**KIRKLEES METROPOLITAN COUNCIL
INVESTMENT & REGENERATION SERVICE**

**DELEGATED DECISION TO DETERMINE APPLICATIONS FOR
NON-MATERIAL AMENDMENTS**

Reference No: **2025/NM/92559/W**

Site Address: Buckden Court, Chesil Bank, Quarmby, Huddersfield,
HD3 4EB

Chesterfield 01246 233 235	Cambridge 01223 838 100	Leeds 0113 512 7510
Scale 1:100@A1	Drawn/Checked AM	
Job Number 23042	Date 04/06/24	
Drawing Number 23042-FSA-BC-ZZ-DR-A-2004	Rev P02

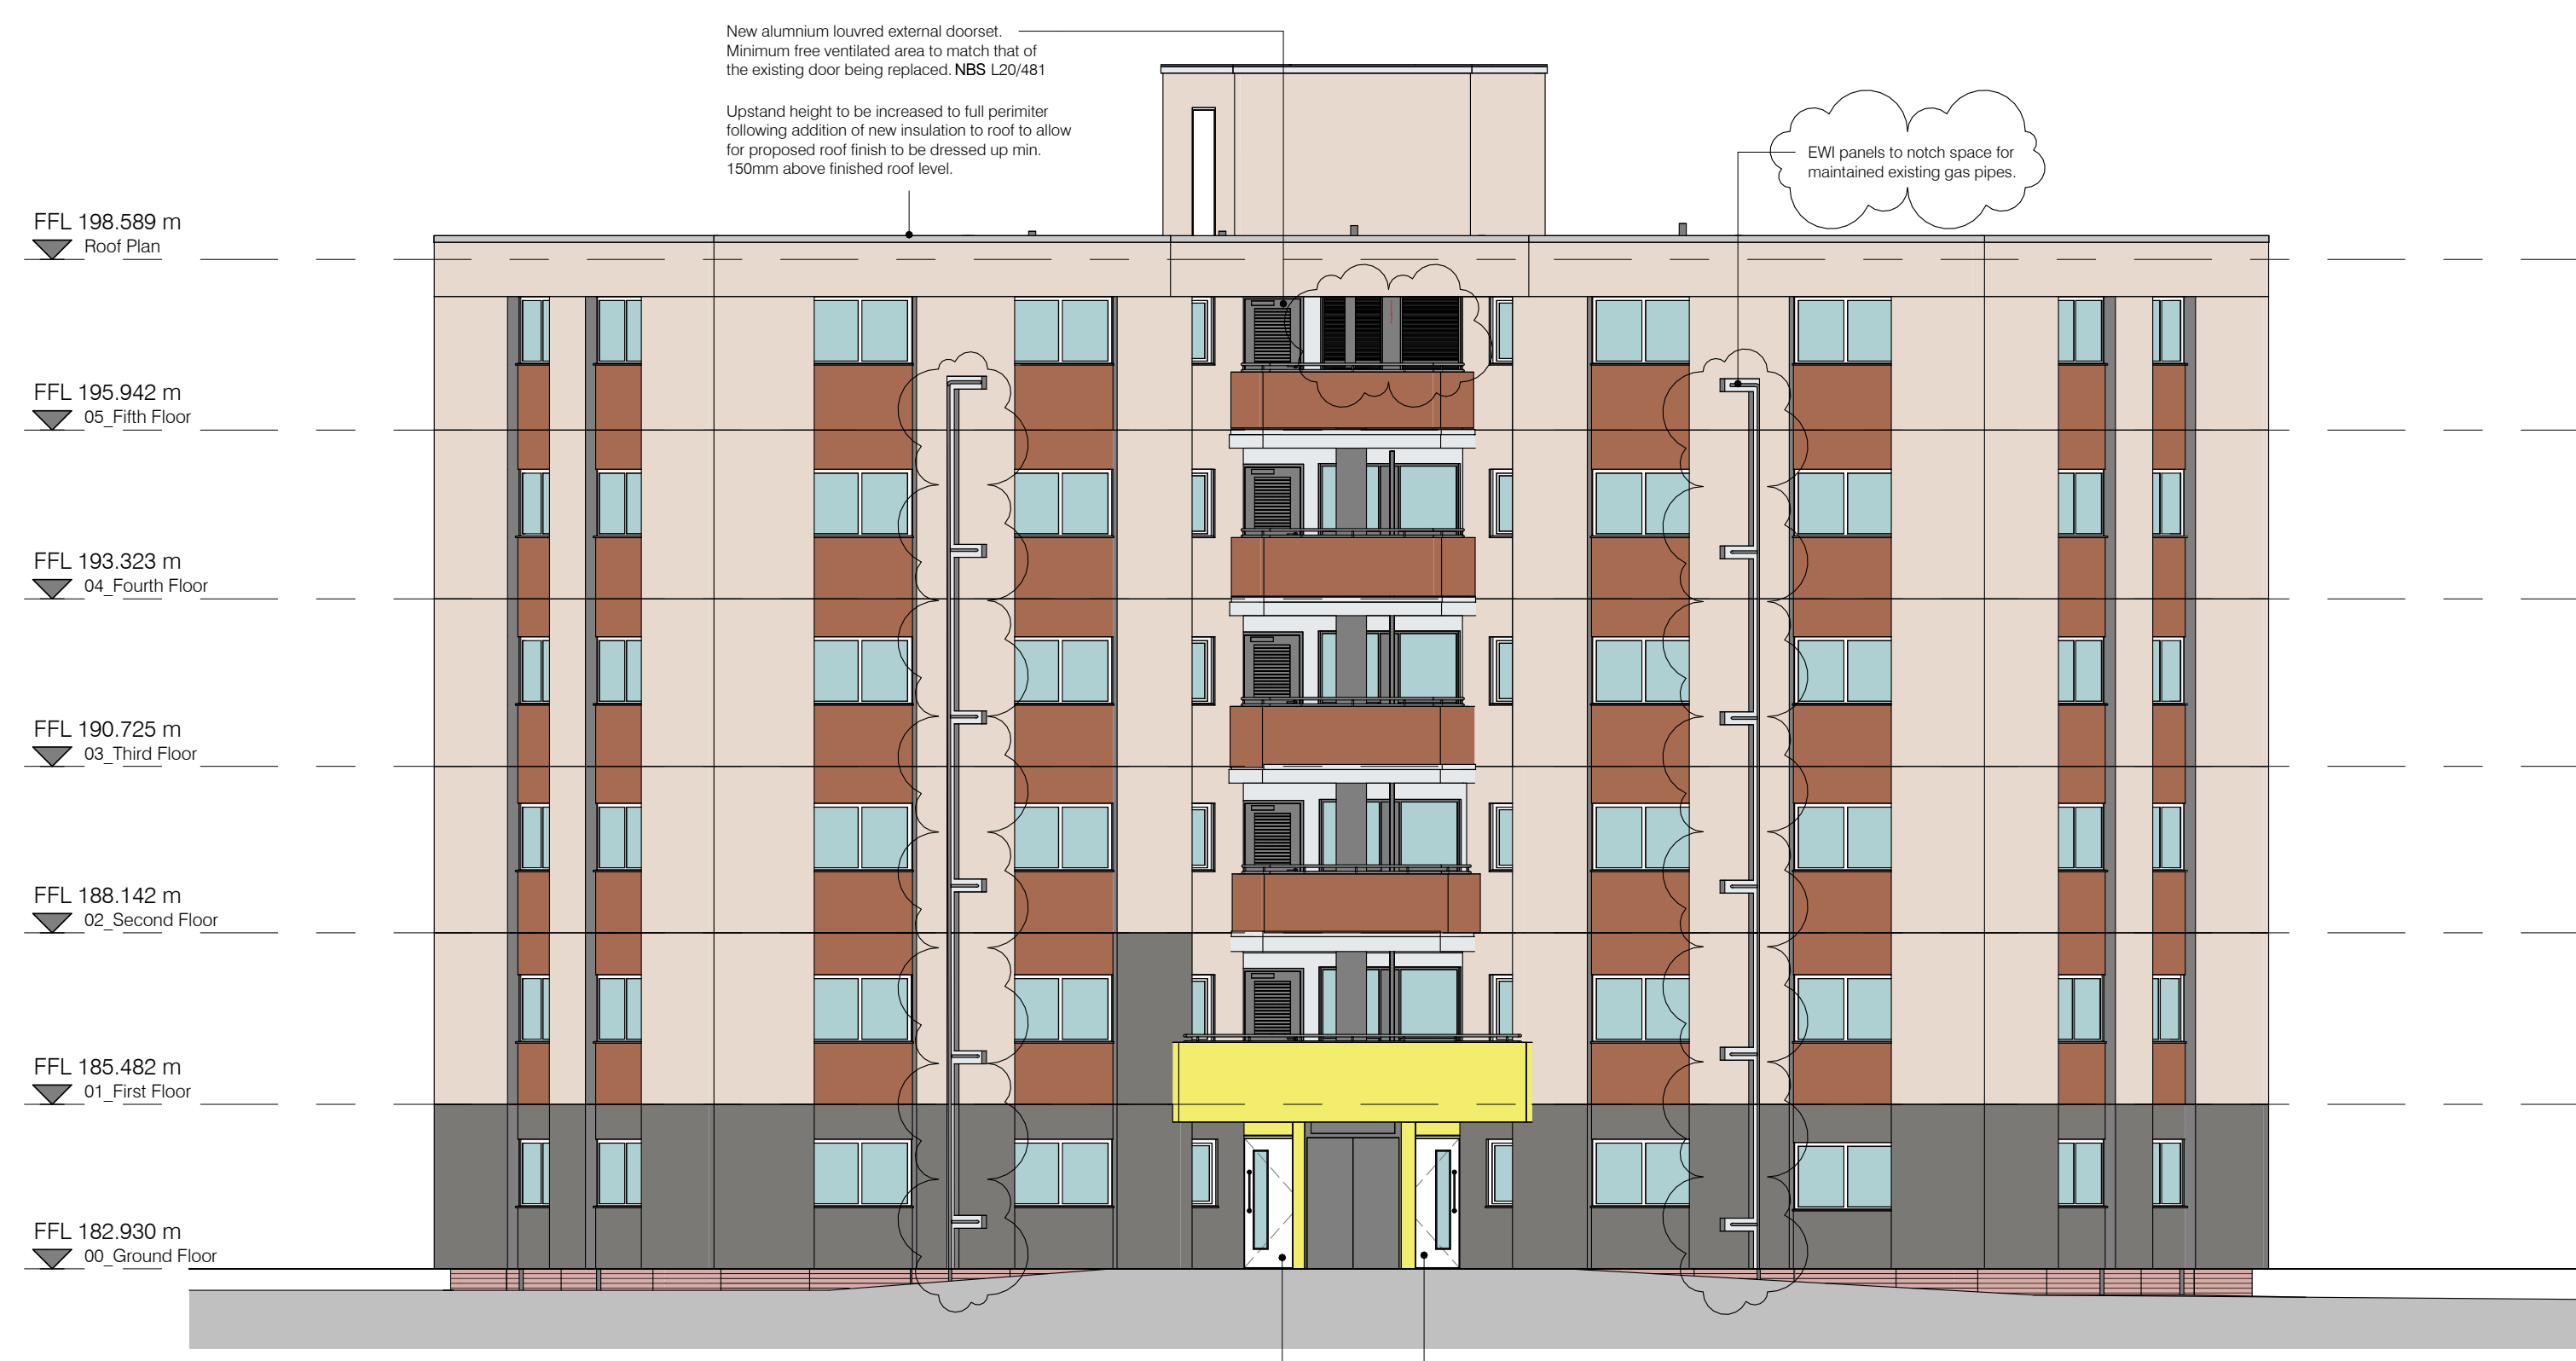
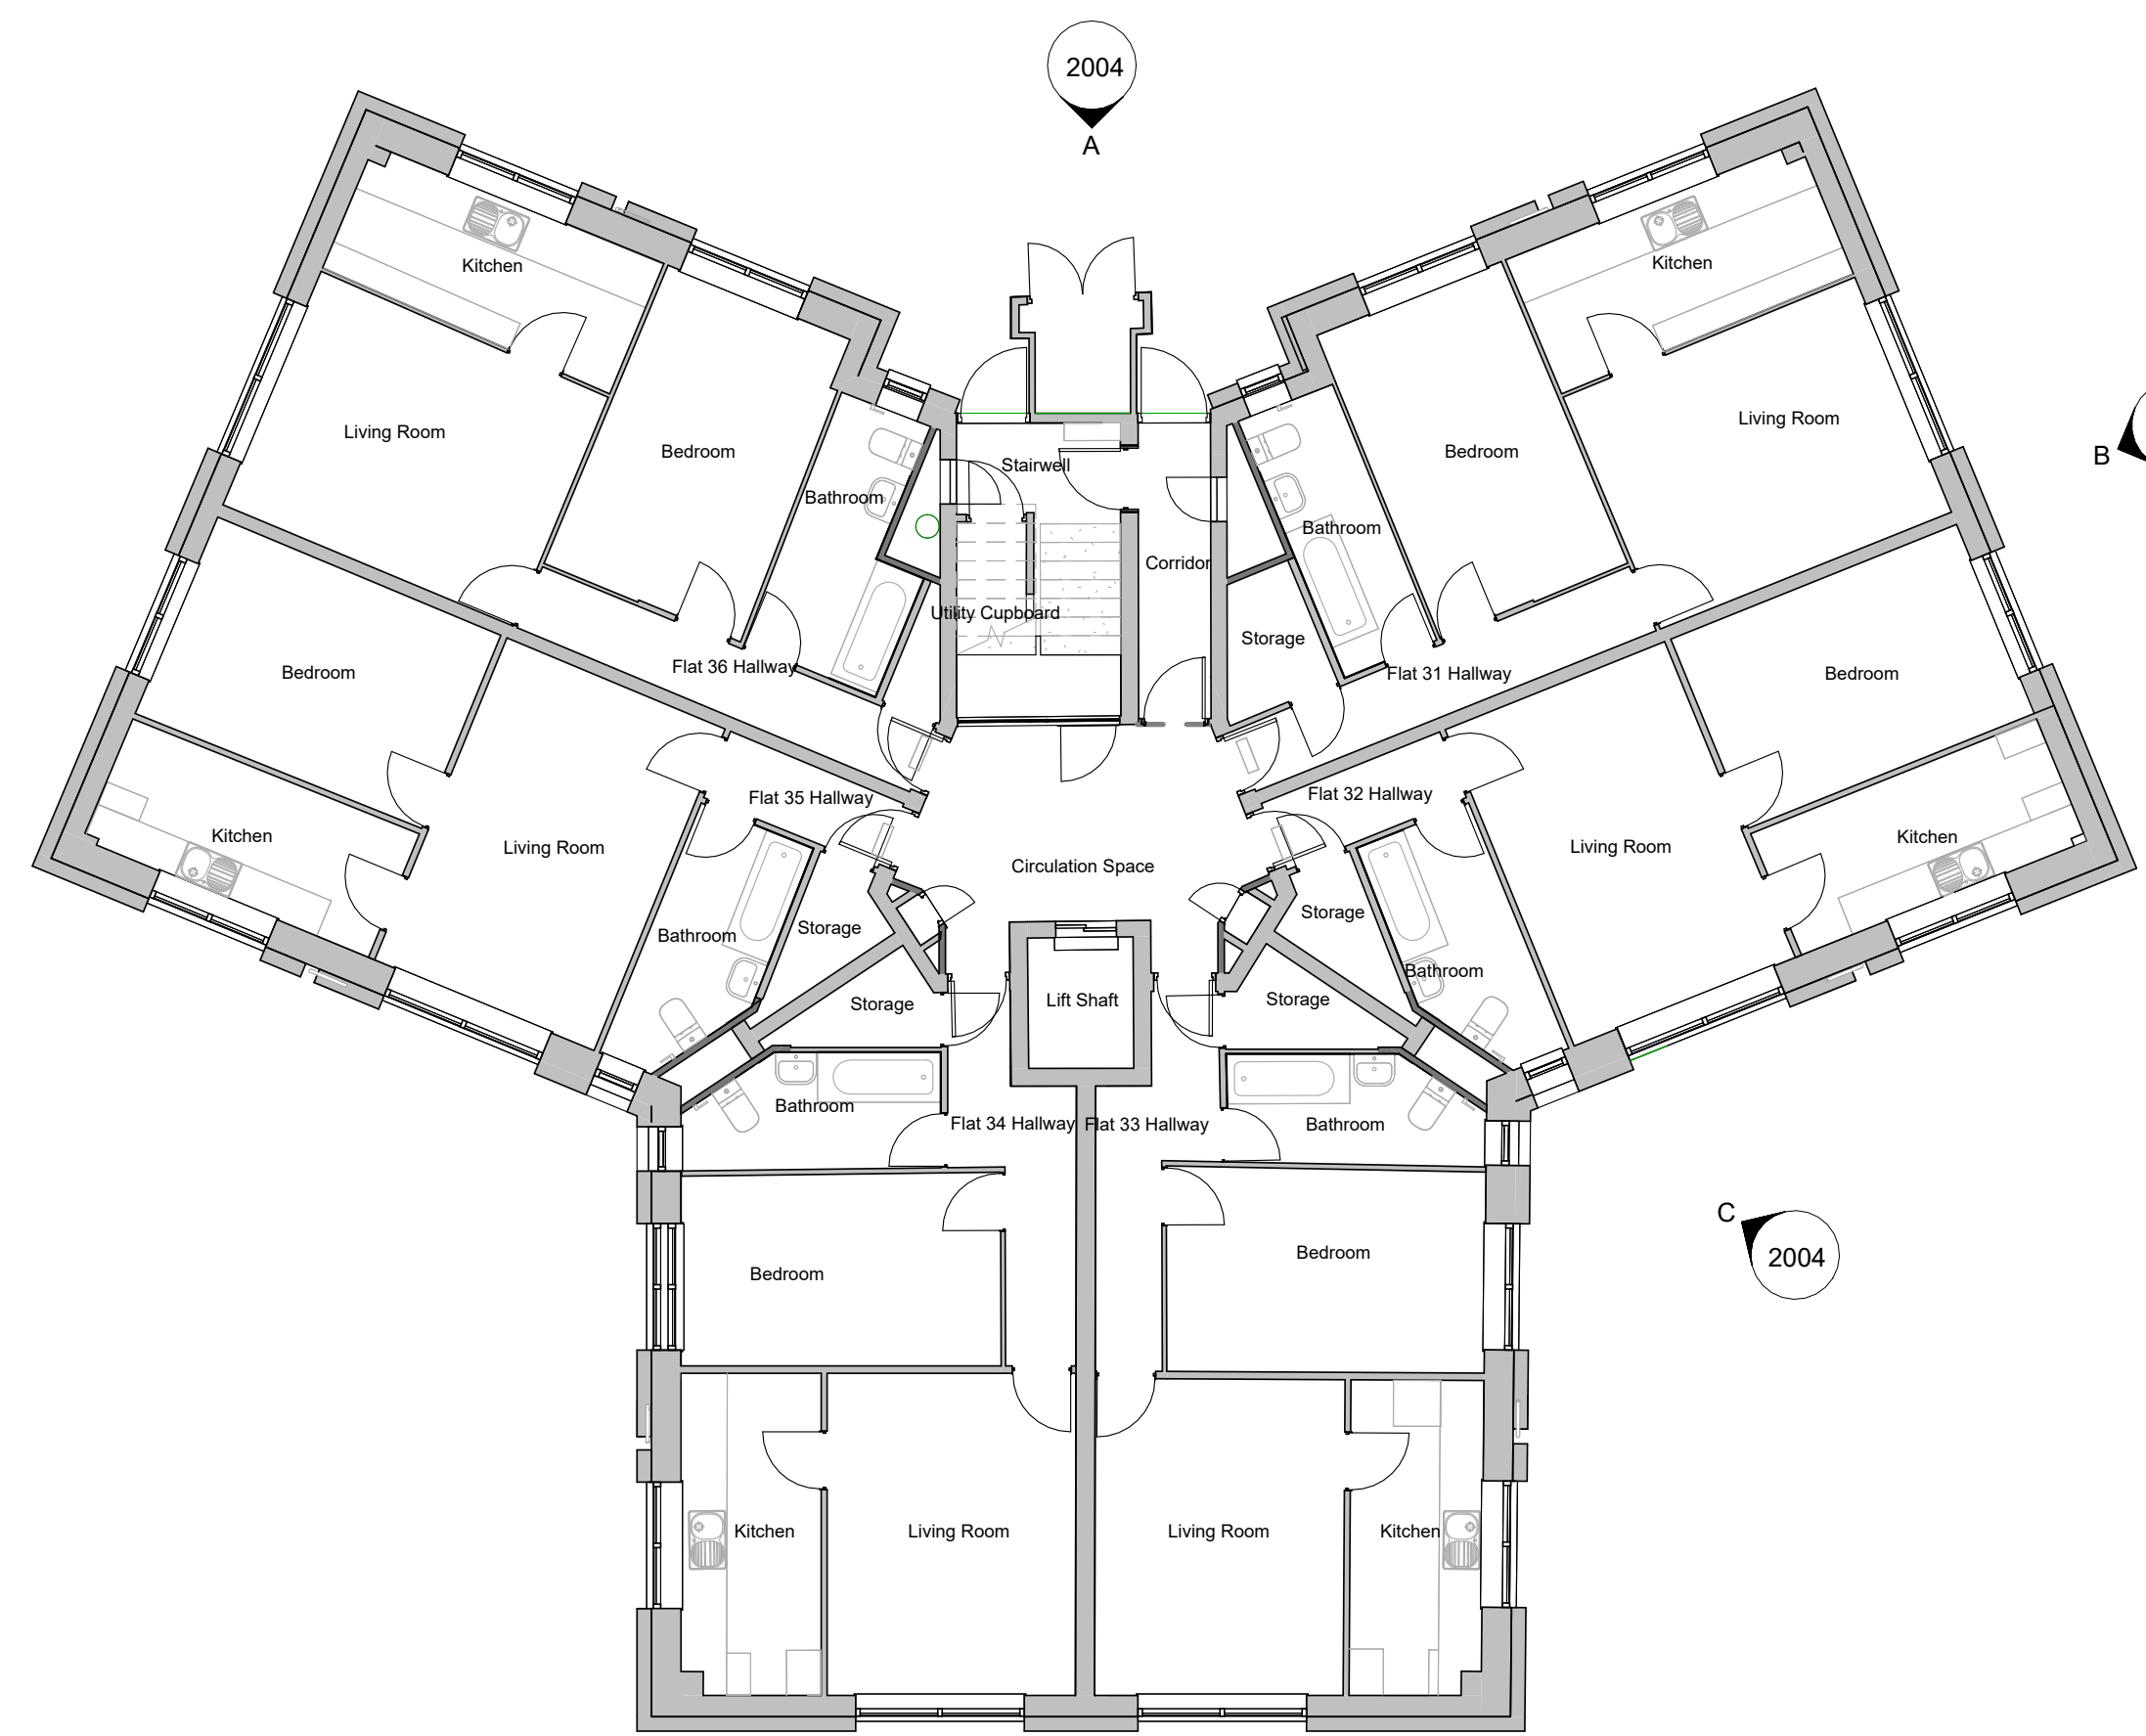
- Space between panels to retain the gas pipes as existing on 6 no. elevations

- Proposed elevations sheet 1 of 2 reference: 23042-FSA-BC-ZZ-DR-A-2004 Rev P02
- Proposed elevations sheet 2 of 2 reference: 23042-FSA-BC-ZZ-DR-A-2005 Rev P02

I confirm that the alterations are acceptable as a non-material amendment to the approved drawing(s) and are hereby approved.
